Subject: CM/44/20/DOC - Land adjacent to Scyld

The submitted Construction Management Plan is not acceptable in its current form. I require the following additional details:

Herrigate
Scyld
Horsemere Green Lane

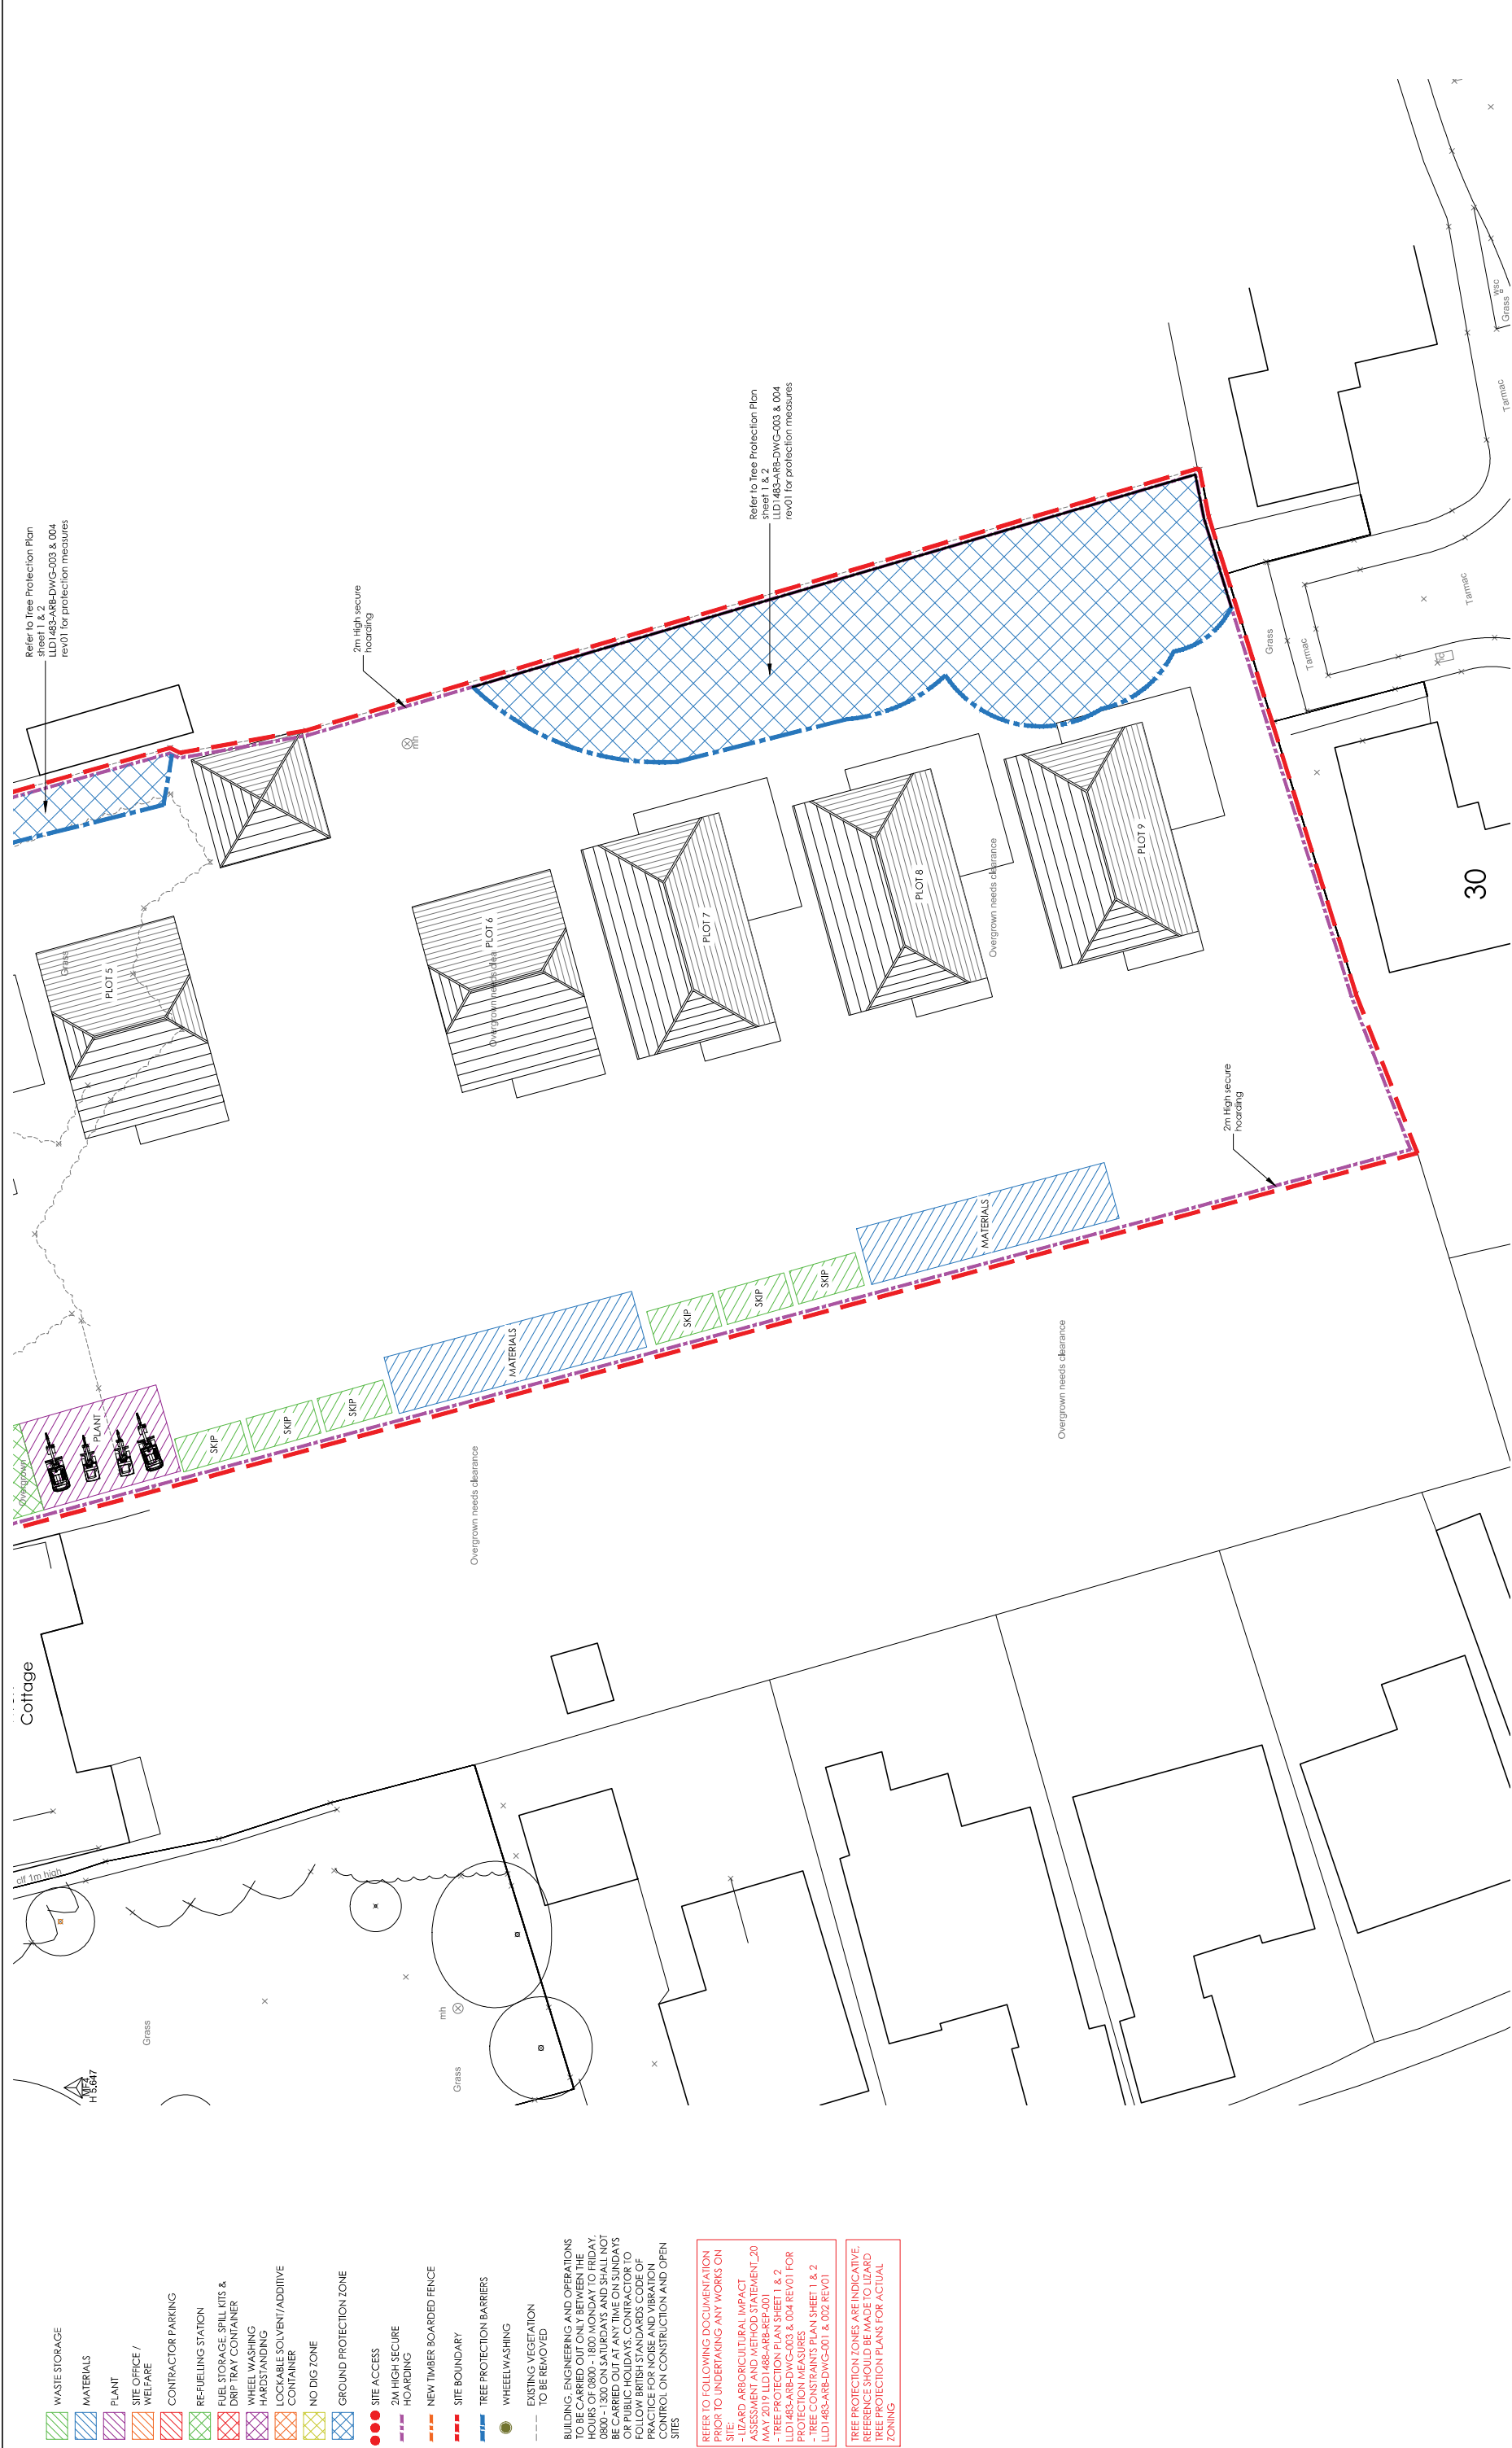
- Confirmation of delivery times - Deliveries will be 8AM - 3.30PM
- Confirmation of hours of operation which should be no greater than 8am to 6pm Mon – Fri and 8am to 1pm Saturday. – Yes confirmed, this is already indicated on the appendix plans series 1111-1113

- Security Arrangements – who will hold the key for the site? - Site Manager
- It is noted that 'debris and mud will not be permitted to enter the access road or public highway', however the road sweeping commentary states it will 'take place on a regular basis to minimise spread of debris on the internal road network' – will there be any cleansing measures for Horsemere Green Lane in the event that mud/debris were to enter the road? -Wheel wash will be in place at the entrance as shown on the CMP drawing series 1111-1113 & hire purchase will be set up for road sweeping as and when necessary.
